Re: Global Storage TIS
3421 Coors Blvd NW
Traffic Impact Study-draft, HT#G11D056
Report dated June 30, 2023
Engineer's Stamp -----
Via email tbrown@tierrawestllc.com

The subject draft traffic impact study received on June 30, 2023, has been reviewed by the City of Albuquerque Planning Development Transportation Section. The City has the following comments to be addressed.

1 SITE PLAN - MAJOR AMENDMENT
AS.1
1" = 30'-0"

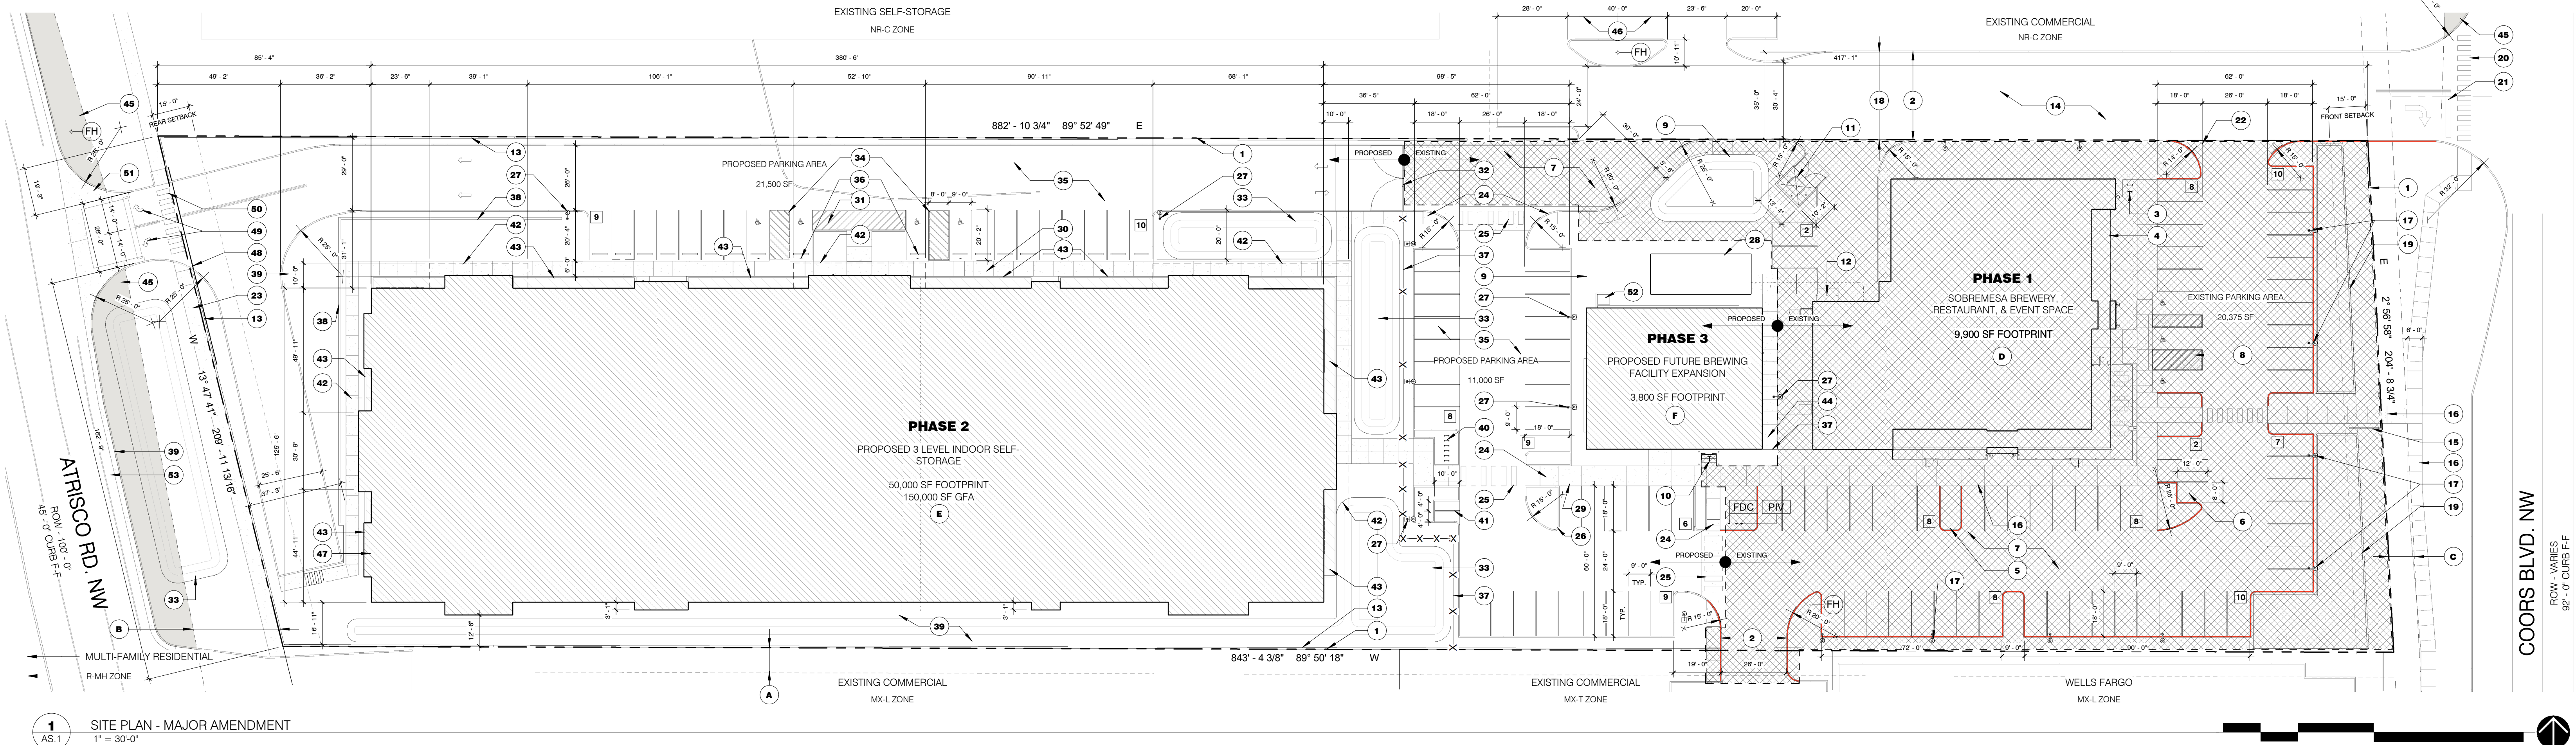
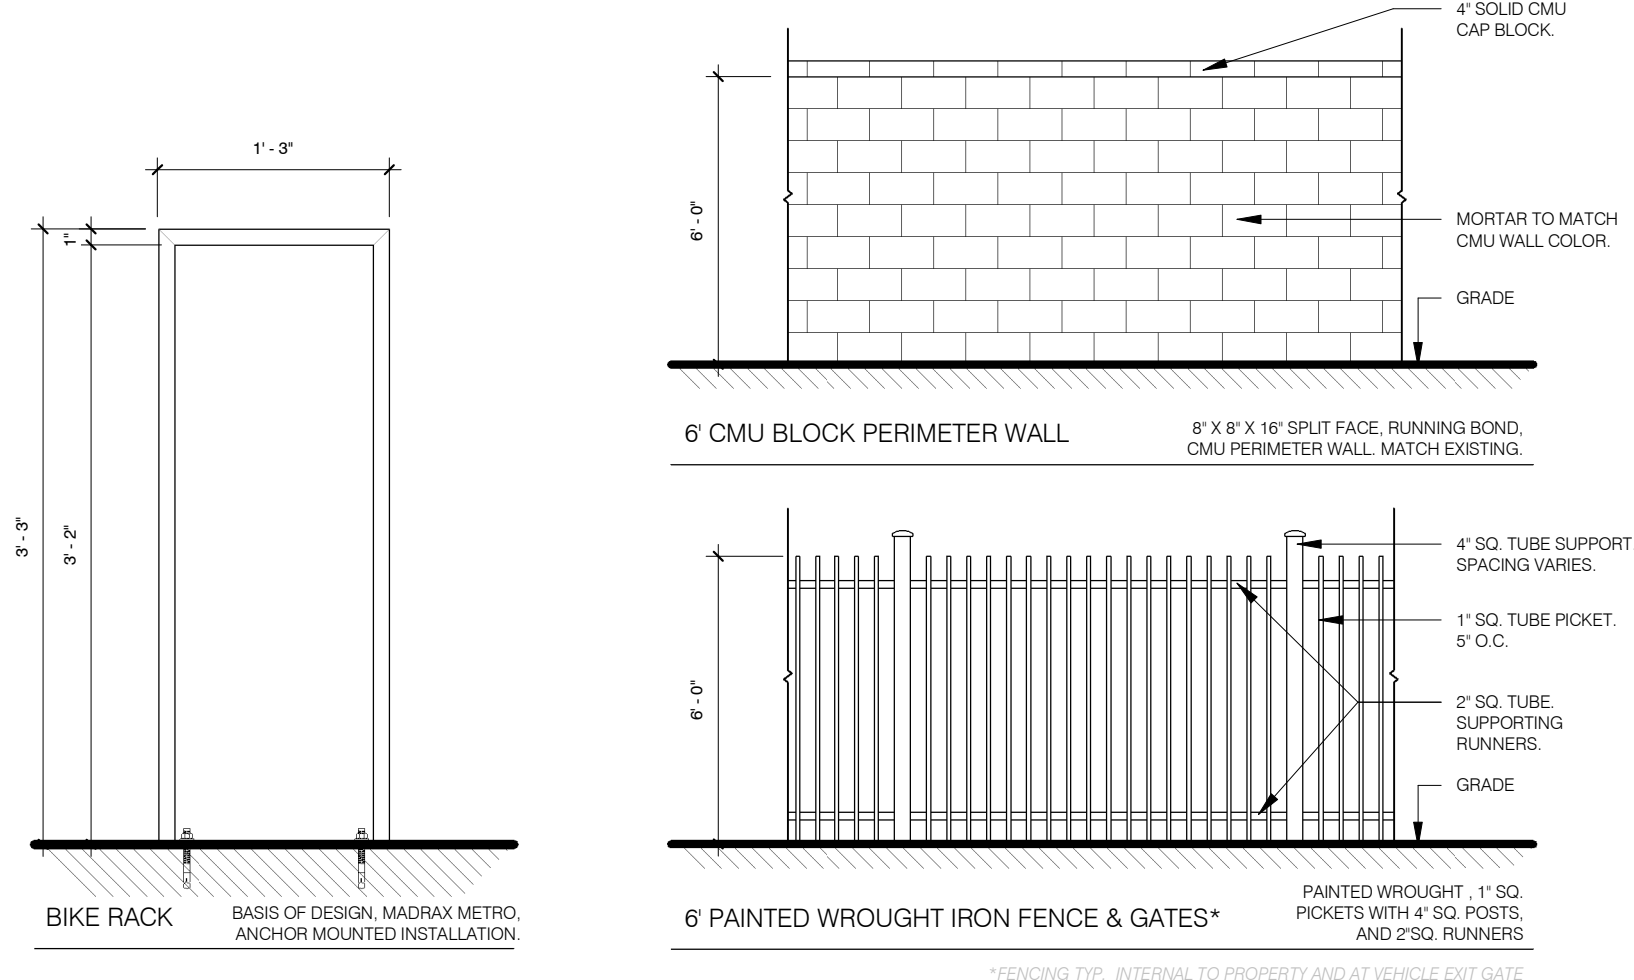
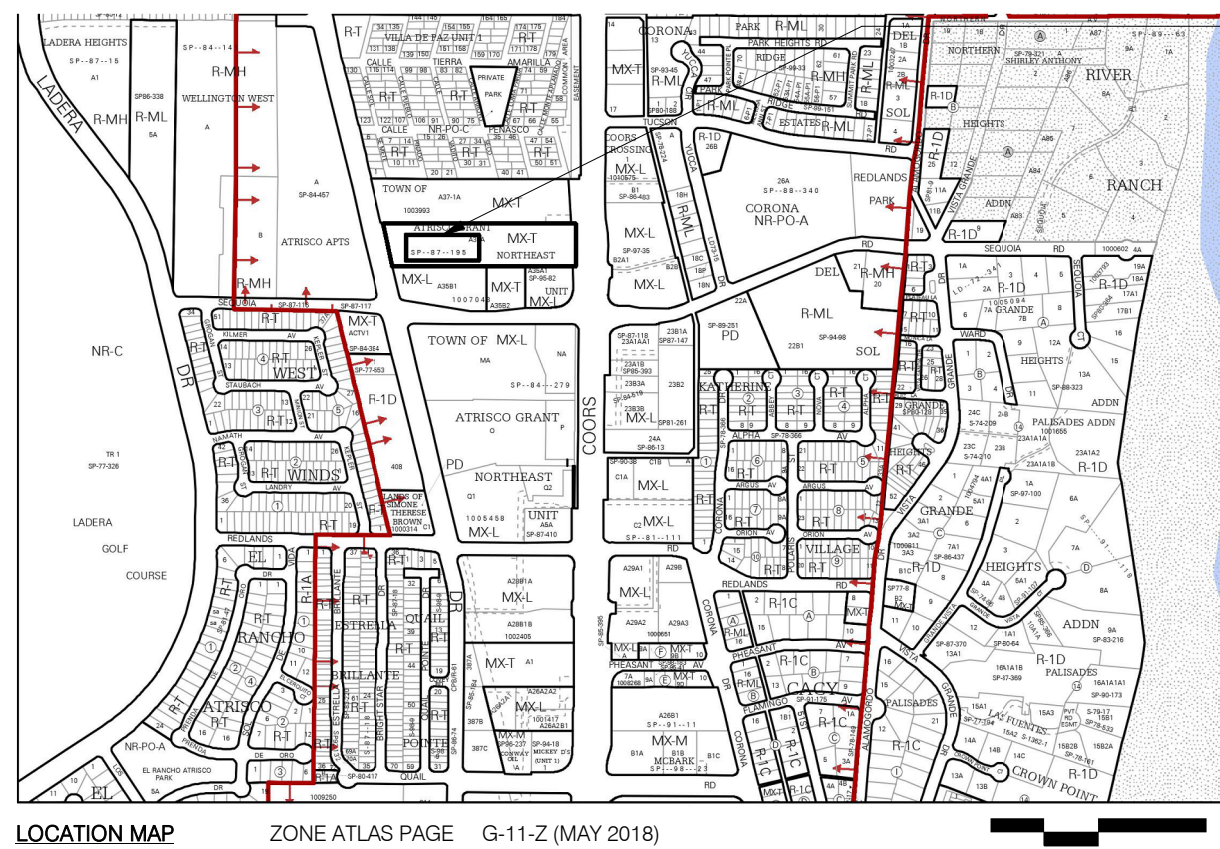
- Describe the restricted access between the storage area and the restaurant/proposed brew pub.
- The driveway on Atrisco Dr. is gated. Describe the access and show the pavement marking arrows on the site plan. Move the driveway dimension line on the site plan to be where the driveway is.
